TfNSW Reference: SYD24-01380-02  
DPHI Reference: SSI-74258485

**ADVICE ON ENVIRONMENTAL IMPACT STATEMENT  
WATER CYCLE MANAGEMENT  
GREATER PARRAMATTA AND OLYMPIC PENINSULA**

## TAB A – TfNSW advisory comments

Figure 3-6e Indicative river release pipeline alignment

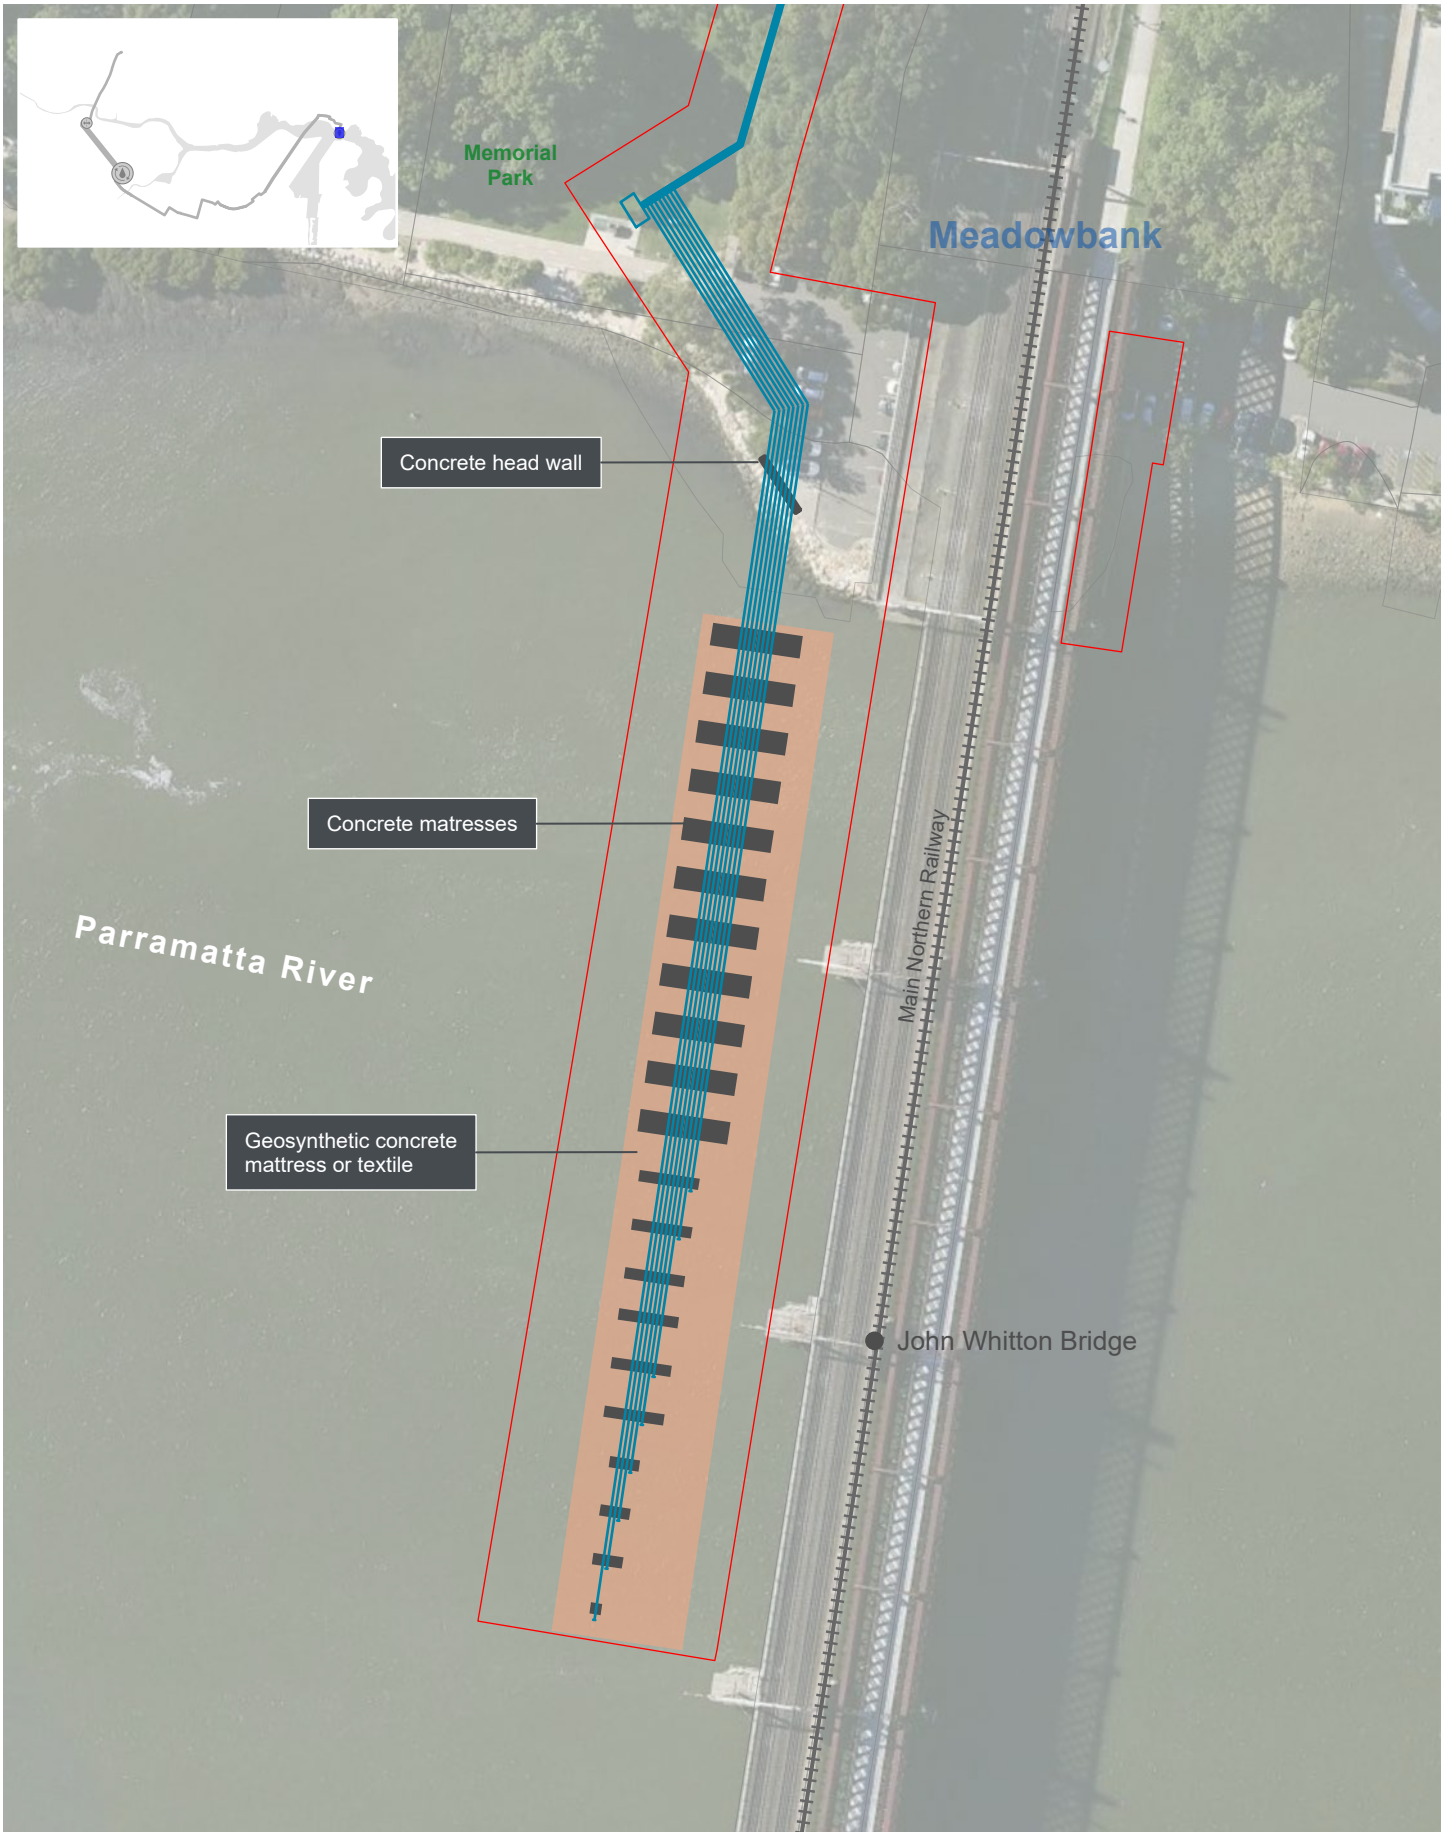
The pipeline at Holker Street is an open trench pipeline. More information is required to understand the interface of this open trench pipeline with PLR2 at this location. Especially, along the existing URBNSURF site where space is limited.

TfNSW team has been coordinating with the Applicant on the concept design alignment of the River release pipeline which interfaces with the PLR2 project at Holker Busway, Hill Road, SOPA Pod 5 Carpark and PLR2 Hill Road TPS site. Further design coordination required with the Applicant to ensure proposed RRP pipeline does not adversely impact TfNSW's ability to construct the future TPS and associated earthing infrastructure, other utility, or drainage assets. Design coordination to be continued as the Applicant's design matures and as Applicant lands on a preferred design alignment (that may be different to what is reflected in the EIS documents).

TfNSW will continue to work and coordinate with the Applicant regarding the respective projects and communicate any design changes. TfNSW would request that if identified through detailed design that changes need to be made by the Applicant that this is communicated to the PLR2 team.

Figure 3-8 Indicative layout of the proposed river release structure

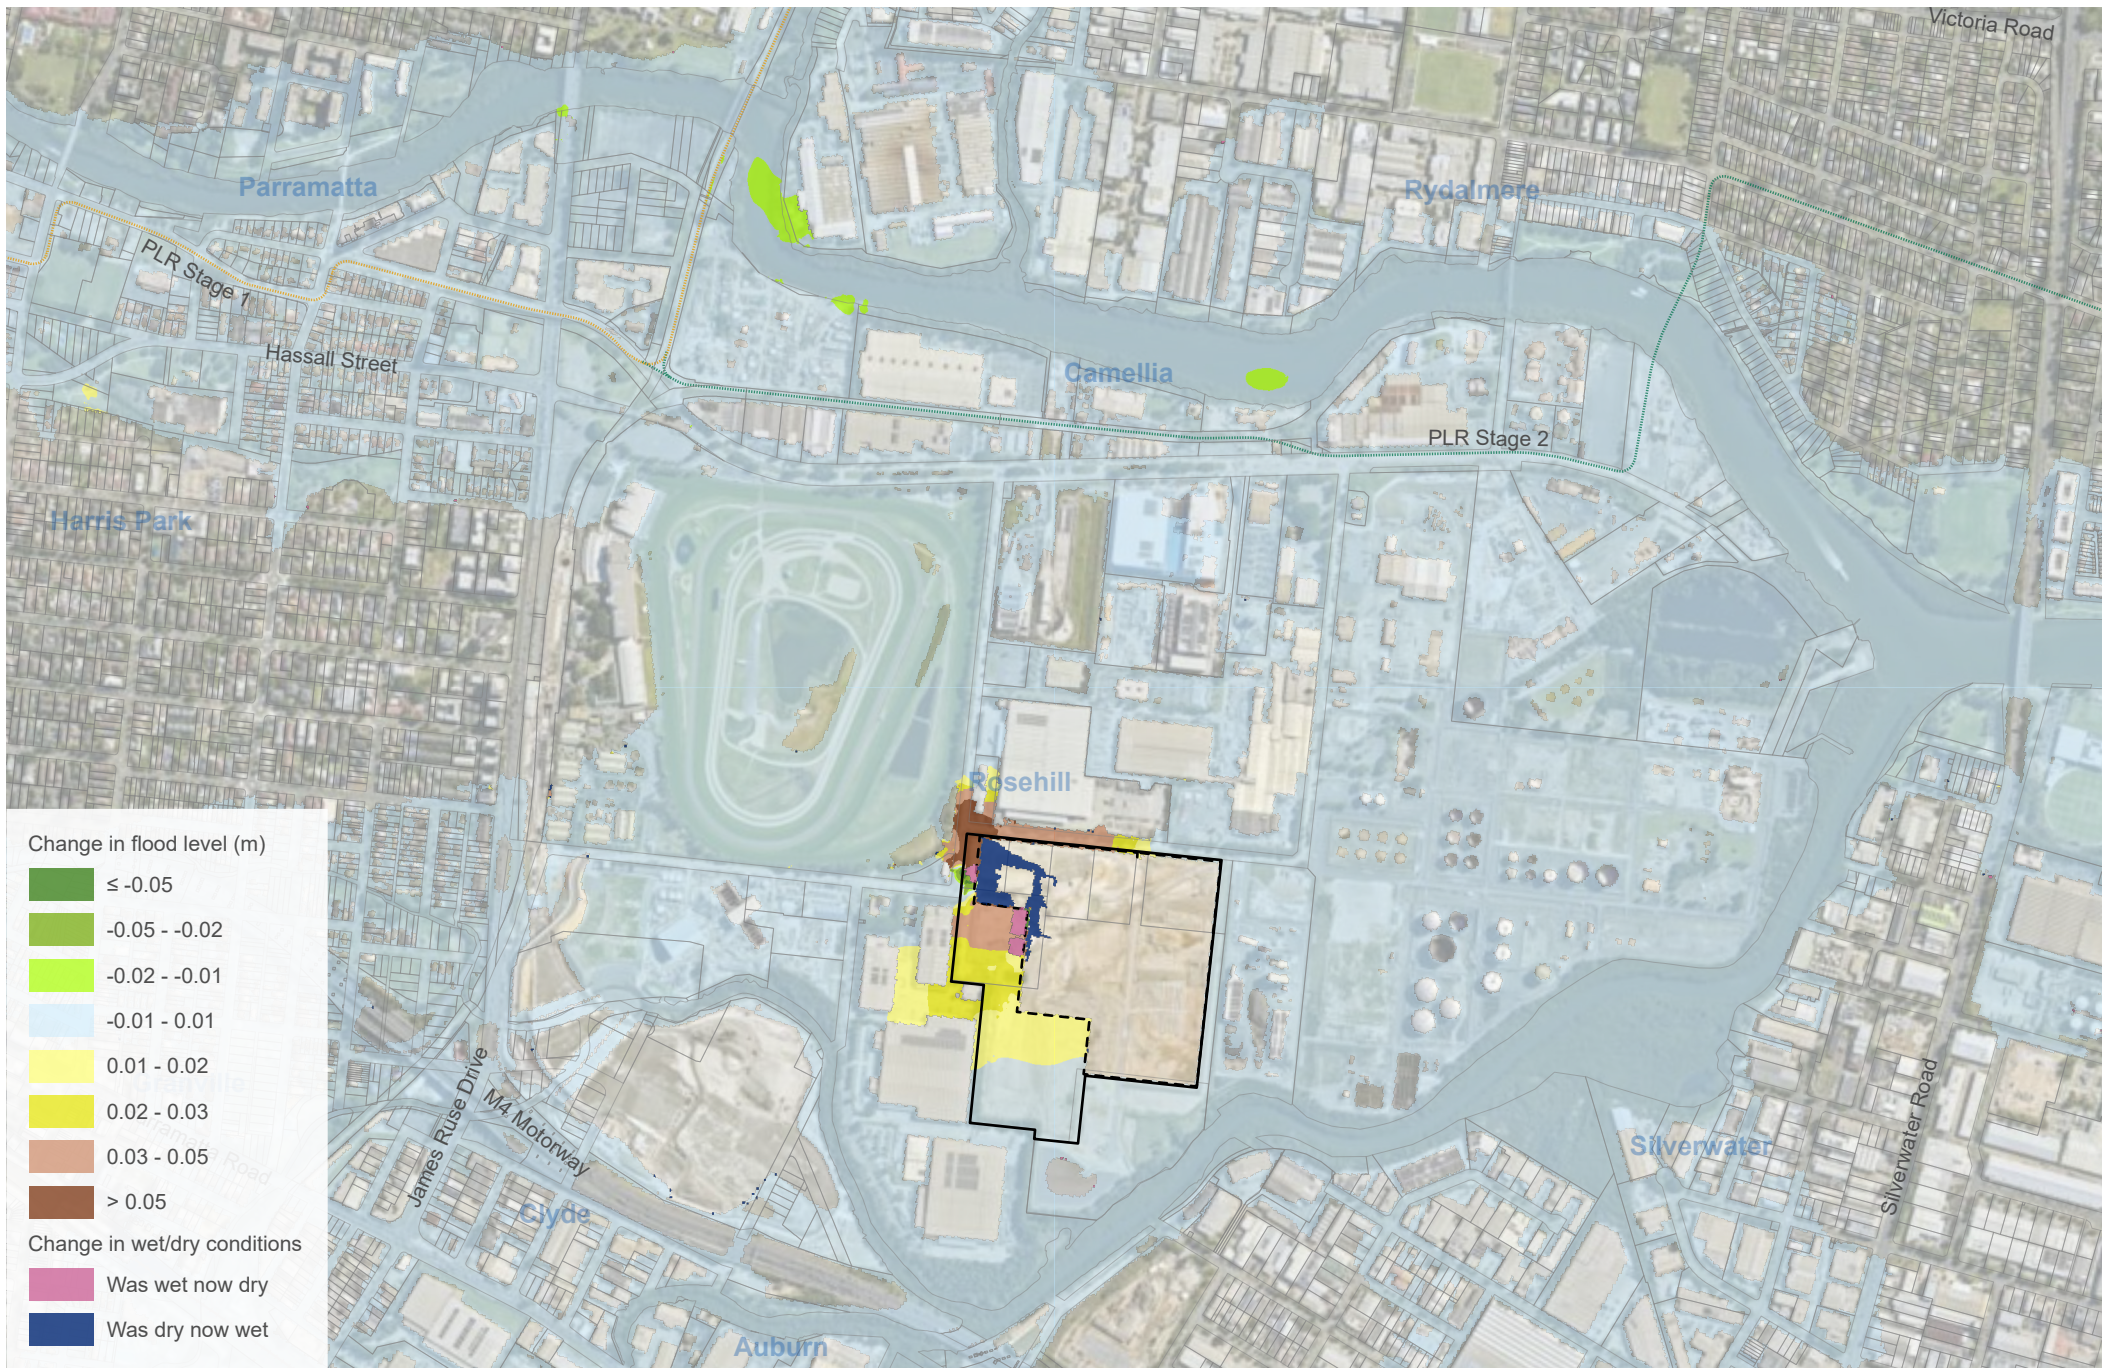
The proposal involves works on or below the bed of the Parramatta River and Duck River, and the installation of the John Whitton Bridge River release structure, which is to be constructed on the bed of the Parramatta River and protected by a concrete mattress.

The EIS and supporting information do not provide sufficient information to assess the potential impacts of these works on boating operations and general navigation safety during either construction or operational stages of the project.

To ensure navigation risks are understood and adequately managed, it is recommended that the proponent as part of the RtS provide a Navigation Impact Assessment and a Waterway Management Plan, prepared by a suitably qualified consultant. These documents should assess impacts to navigable waterways at all stages of the project.
